From: Tim Trowbridge <tim.trowbridge@centurylink.net>
Sent: Tuesday, March 02, 2021 12:04 PM
To: Tracey Garcia; Craig Dossey; Mark Gebhart; Nina Ruiz
Subject: Comments on PC items 4 March meeting

SP-19-003 Preliminary Plan - Windermere

Figure 1

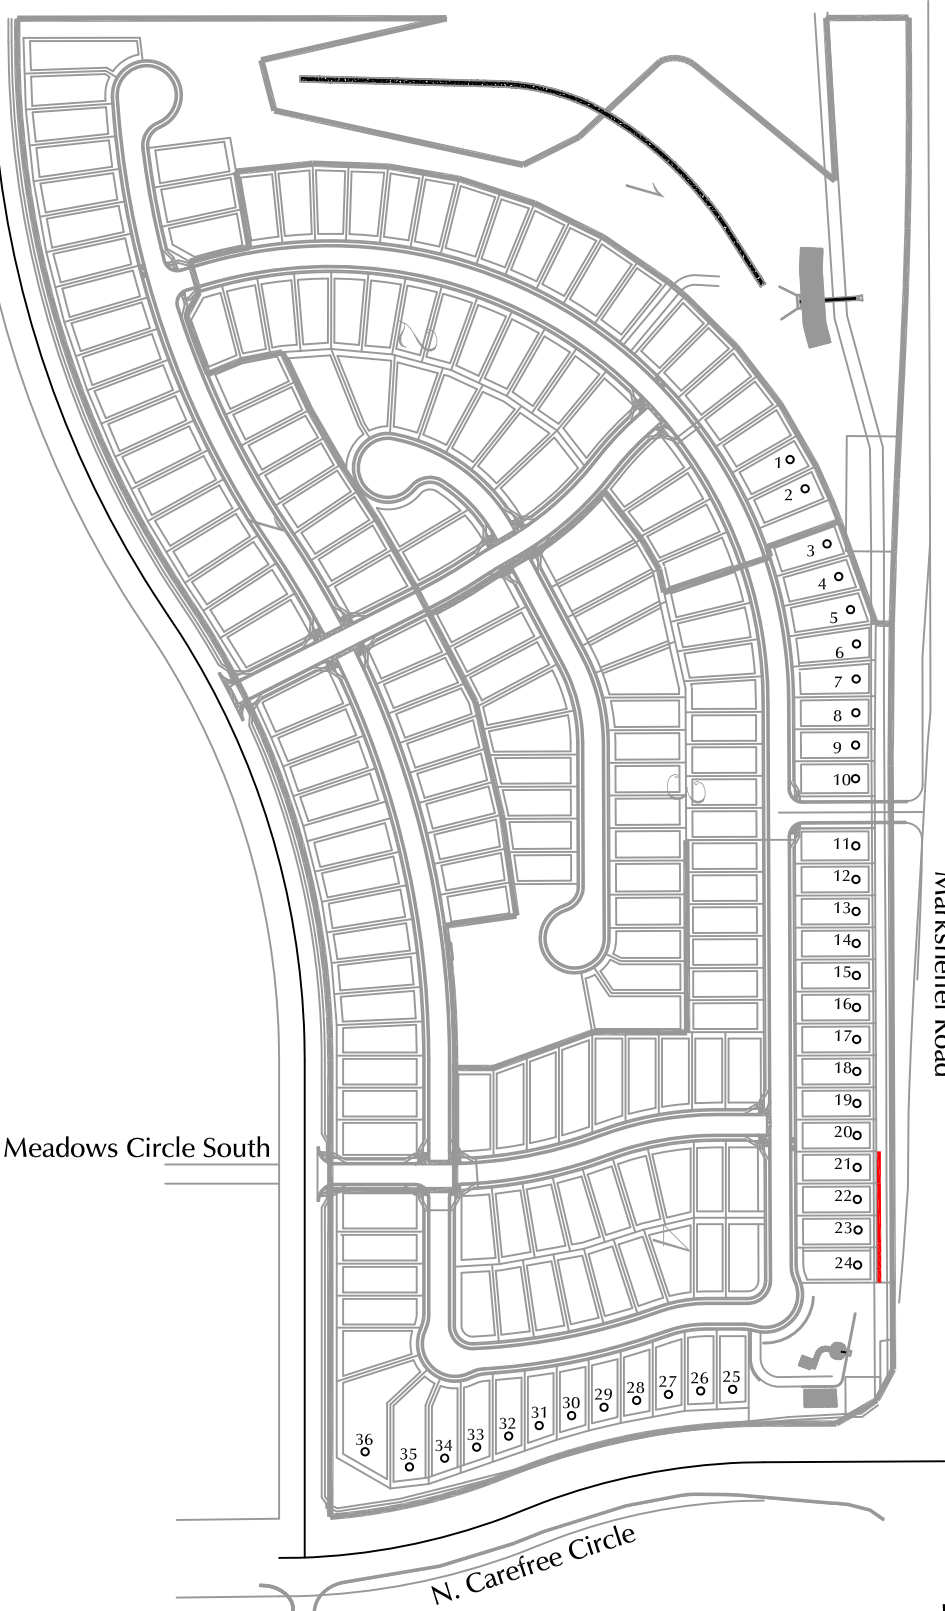
Condition 6: what is the determining factor for 6 vs 8 ft wall?

Is that a result of the updated study? Why not just specify one and be done?

Condition 6: what is the determining factor for 6 vs 8 ft wall? **The Noise study completed by the applicants consultant. Is that a result of the updated study? Why not just specify one and be done?**

Recommended Condition No. 6 requires an updated study to determine if a wall is requires along N. Carefree which will identify the height in the areas that need the mitigation at time of final plat. Not all areas require same mitigation (height of wall). With development rising in the area, staff wants to finalize the wall requirements at final plat to help to ensure the future residents have the appropriate noise mitigation.
